19th June 2020

Application No: EP/67/20/PL
Site Address: Land adjacent to 45 The Ridings East Preston BN16 2TW
Description of works: 1 No. detached house & formation of associated new access.

Thank you for your internet representation made on 18th June 2020 which has been recorded as an objection with the comments as follows:

DWG NO
935/PO1

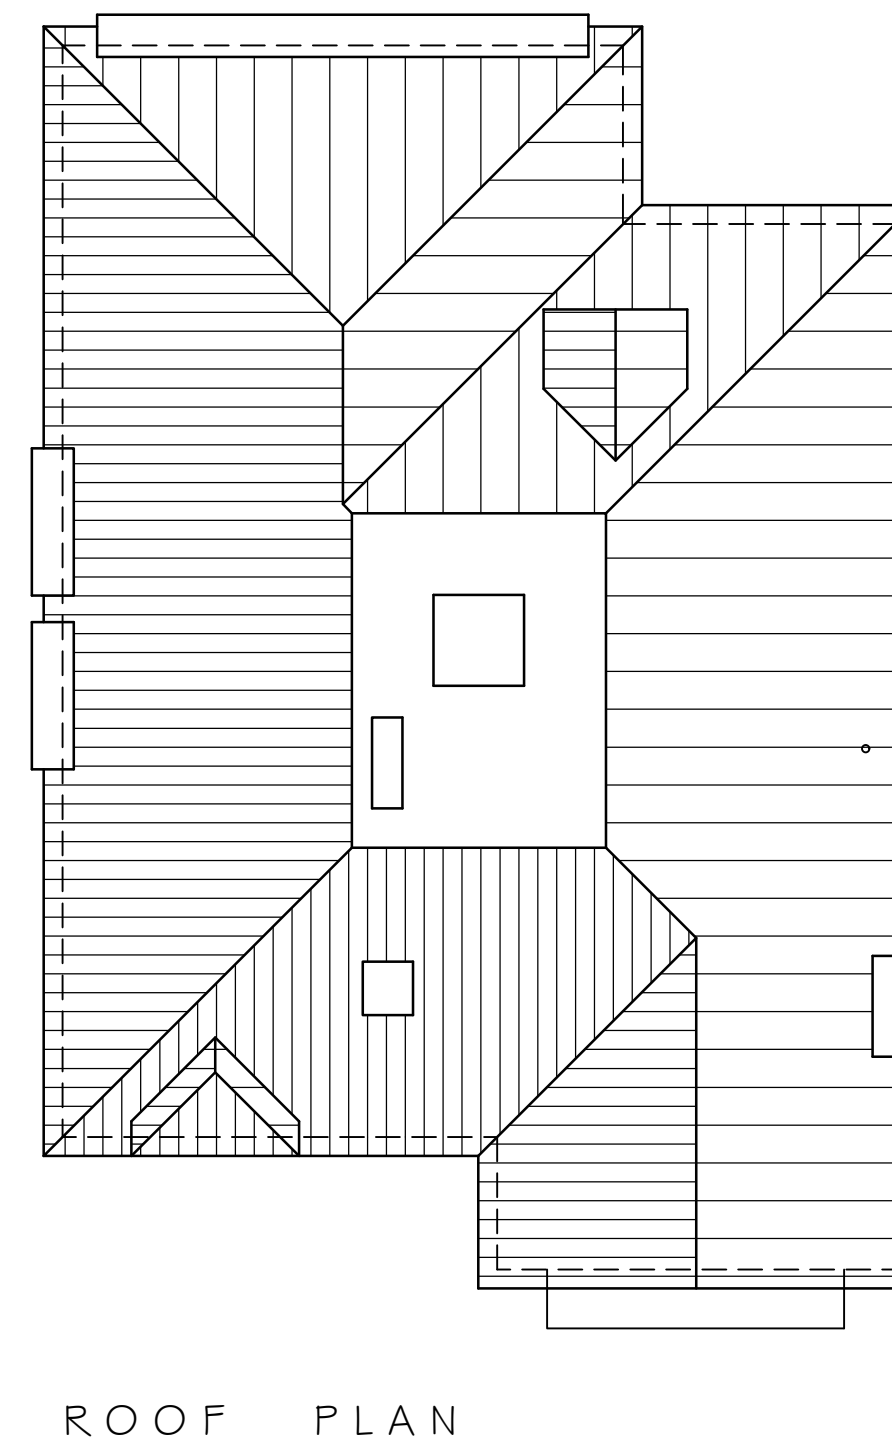
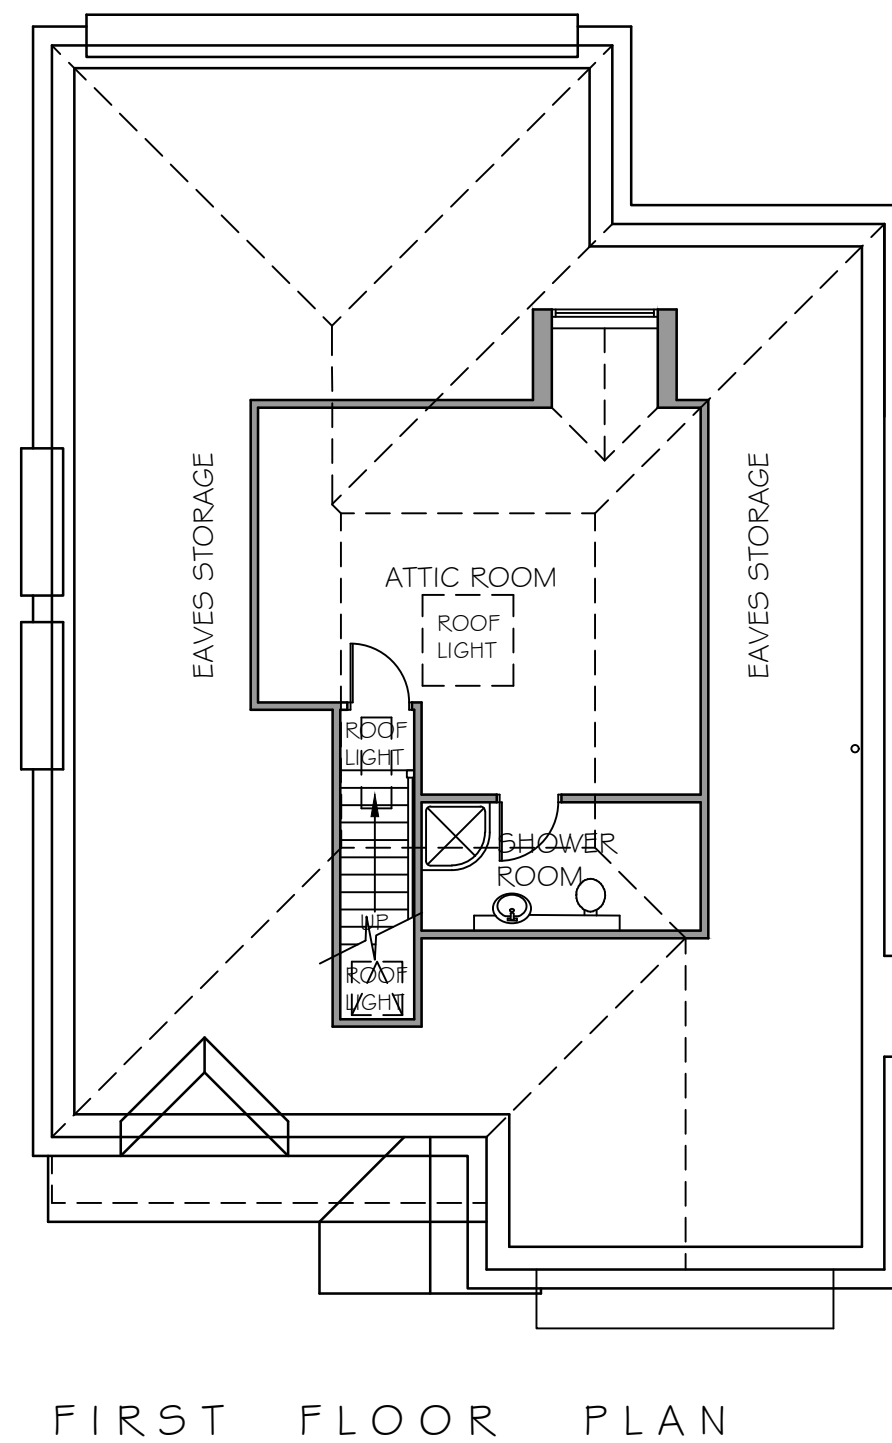
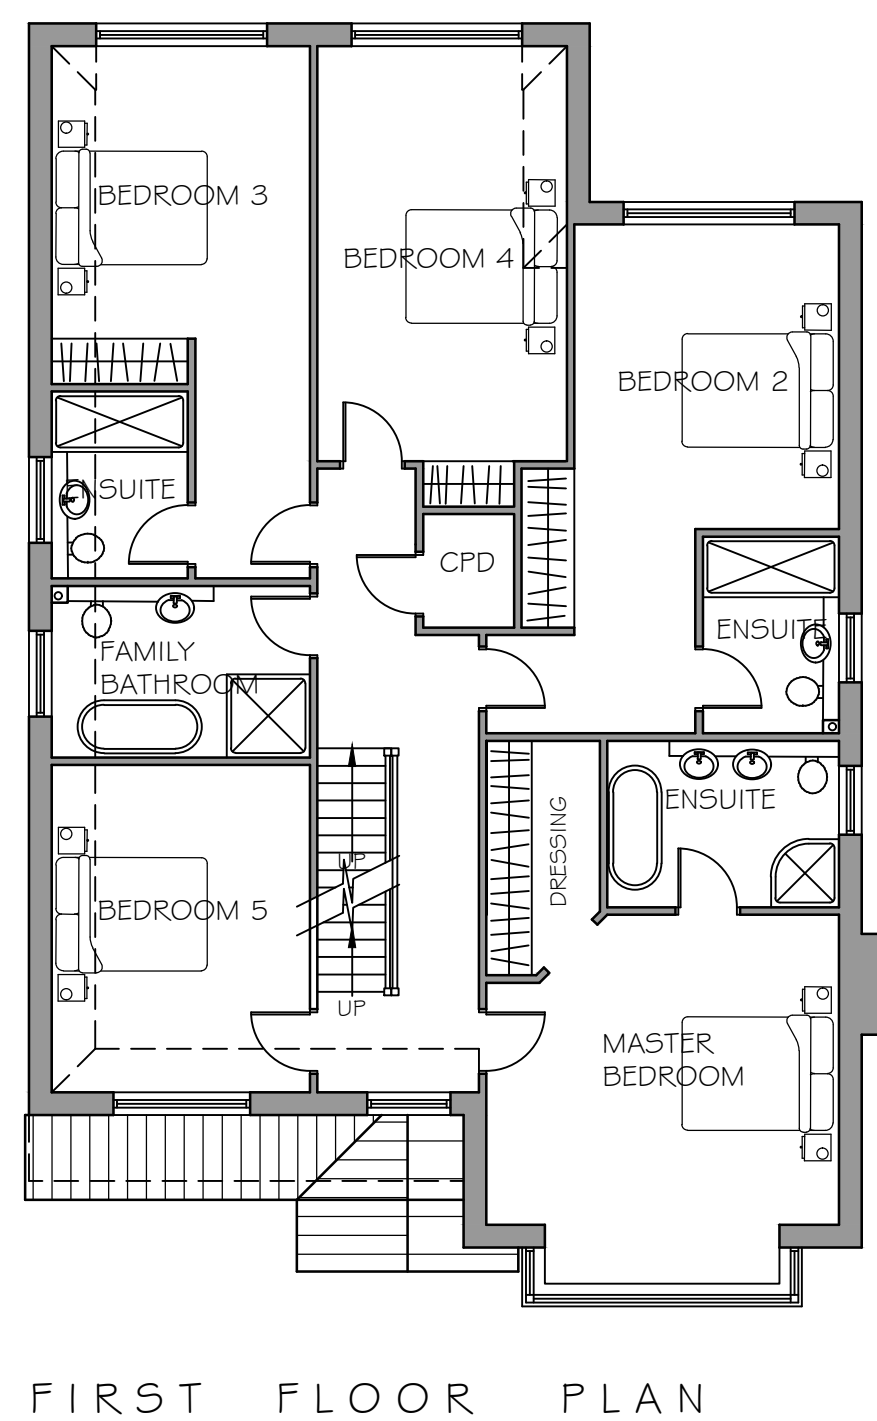
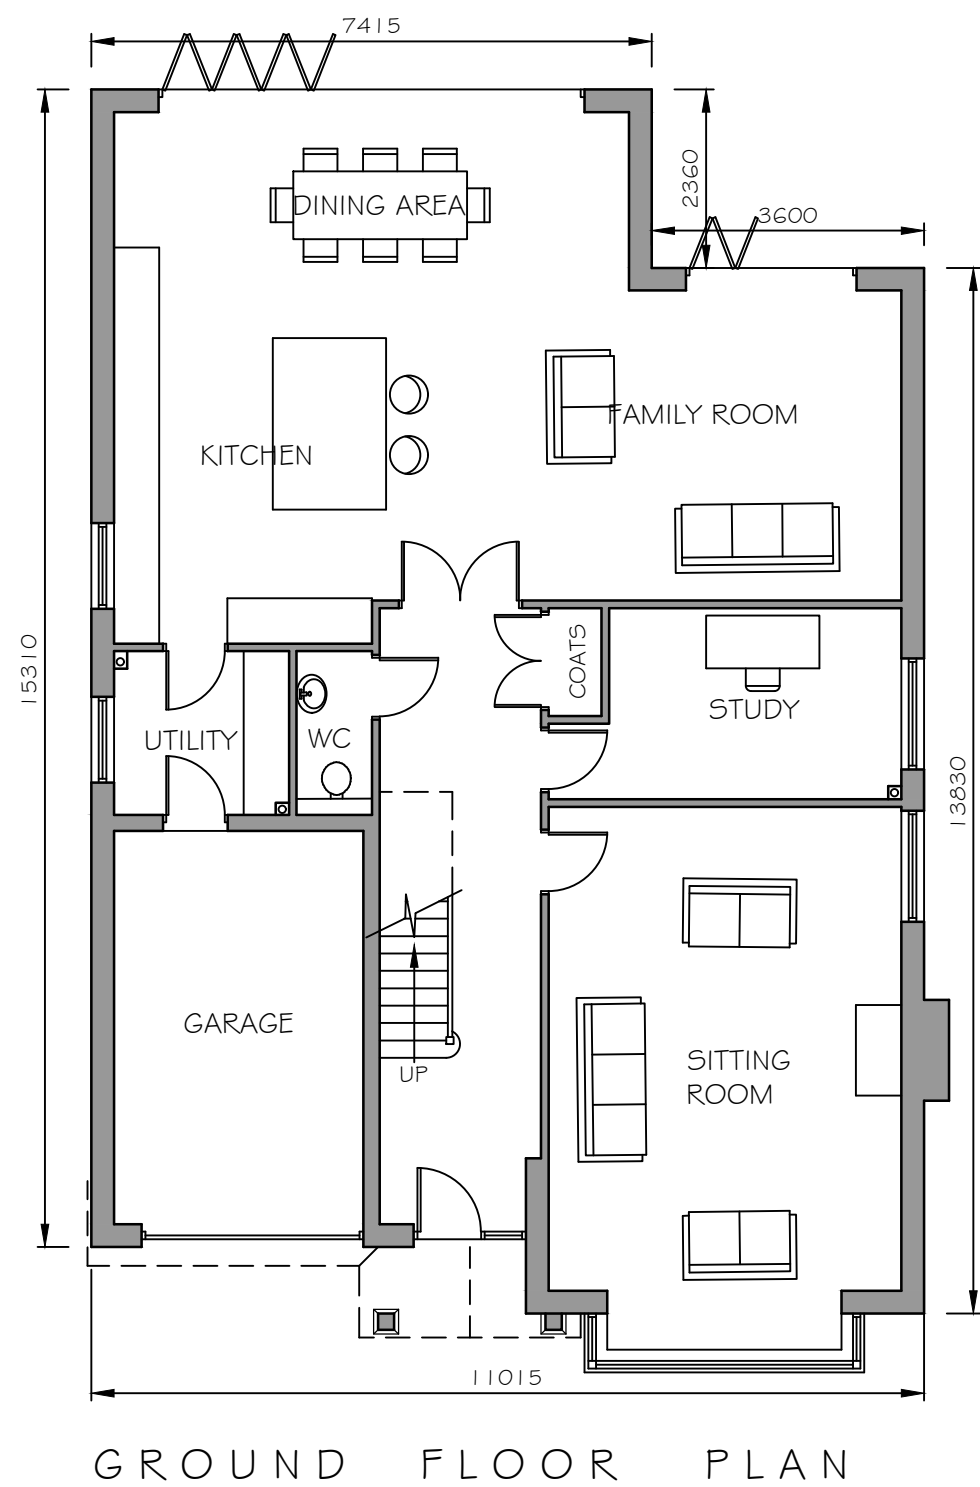
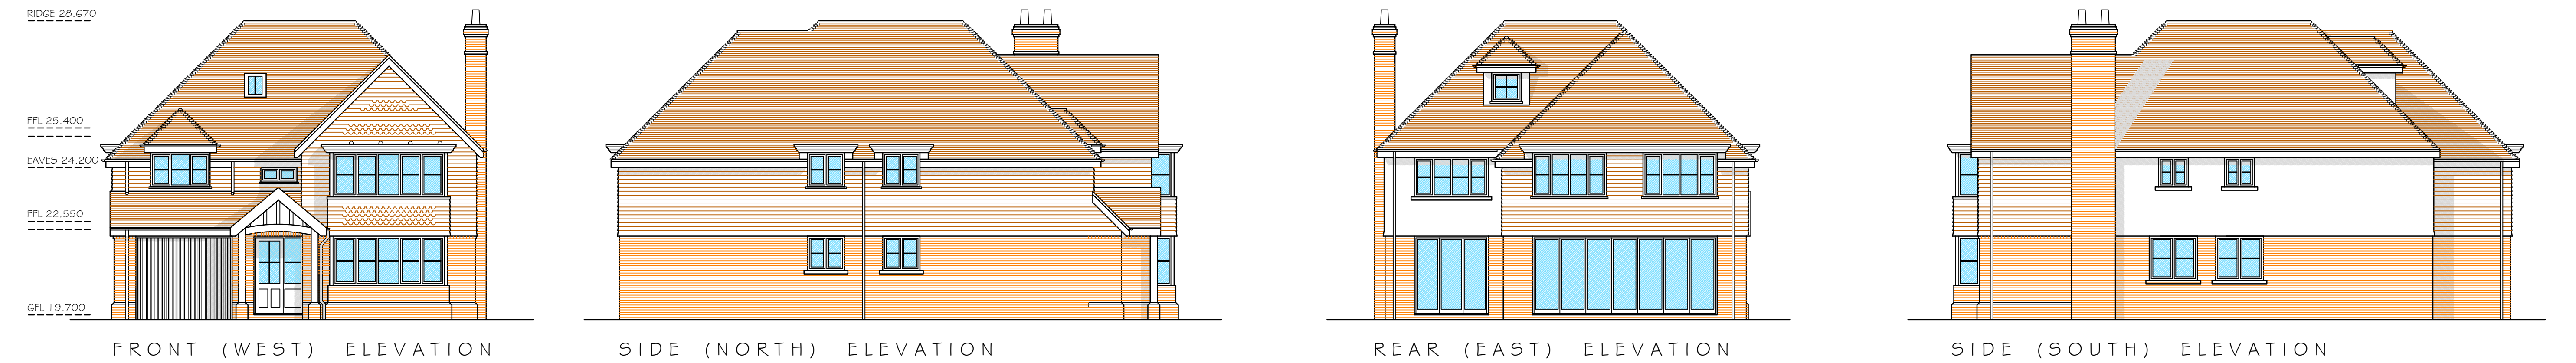
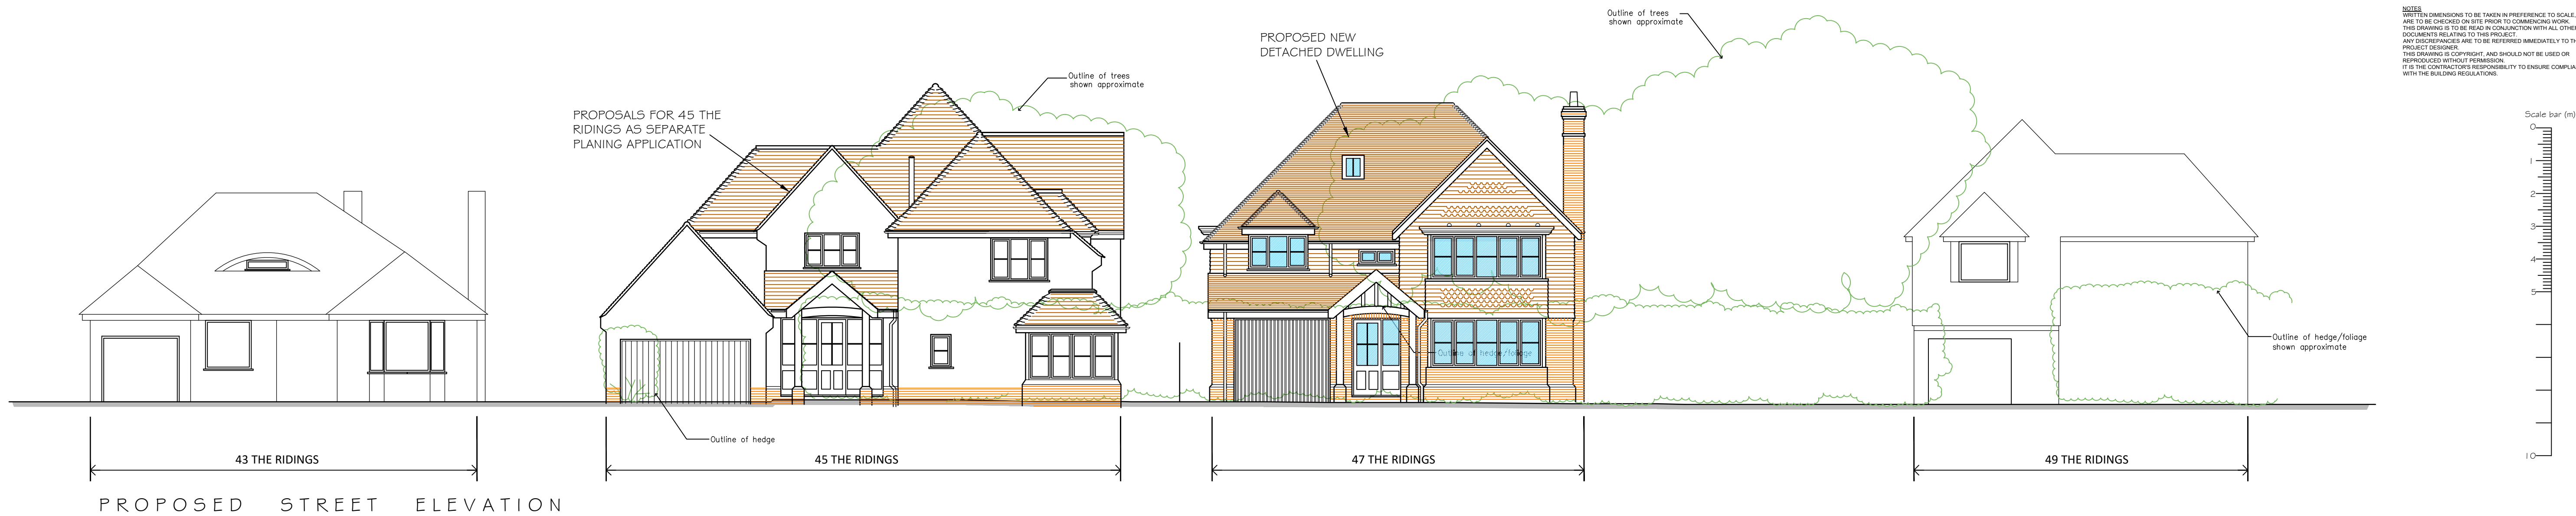
The proposed house is large and totally out of character with the street view, and will destroy the area.

Small garage with external parking space is inappropriate for the proposed development.

Three storeys with a sun room is inappropriate for the area and the designated sun room I fear will simply become over time a further bed room, this further indicates the parking proposed facilities would be insufficient. This would potentially lead to on street parking which would further add to dangers.

DRAWING TITLE
PROPOSED SITE LAYOUT

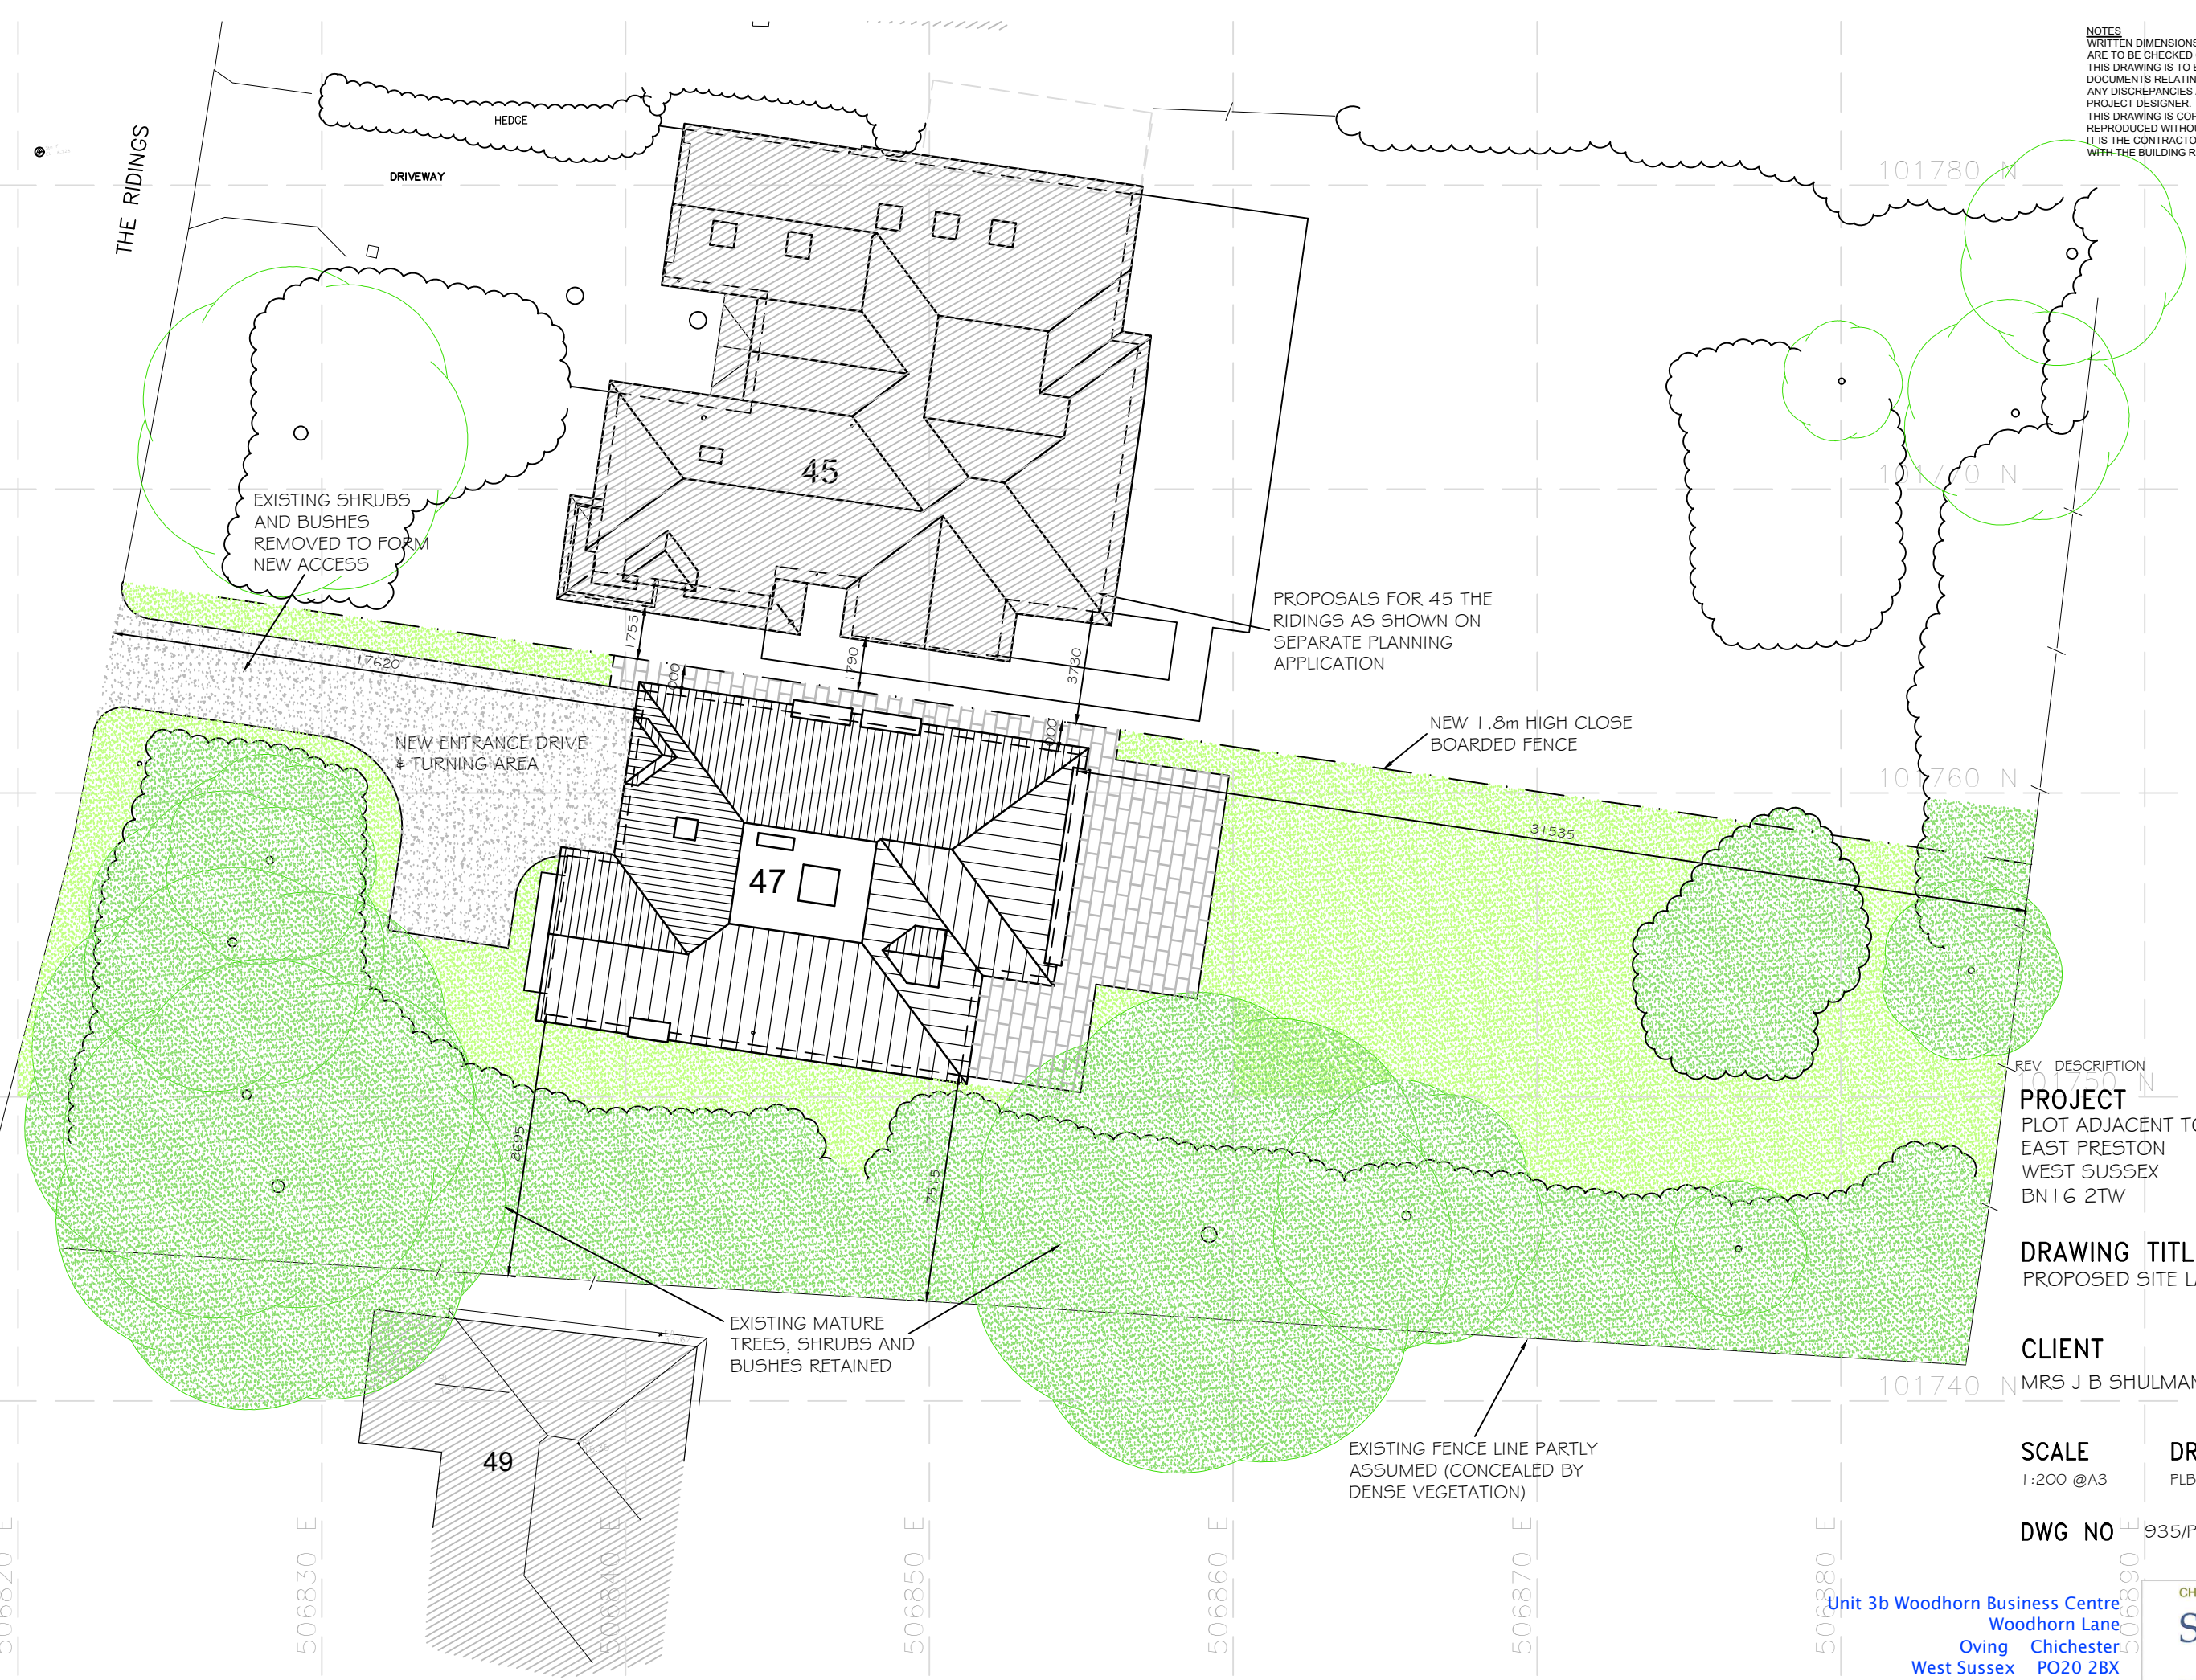
New proposed drive access is dangerous close to the existing road island, and approaching cars will be caught in a "designed" blind spot, not safe or desirable.
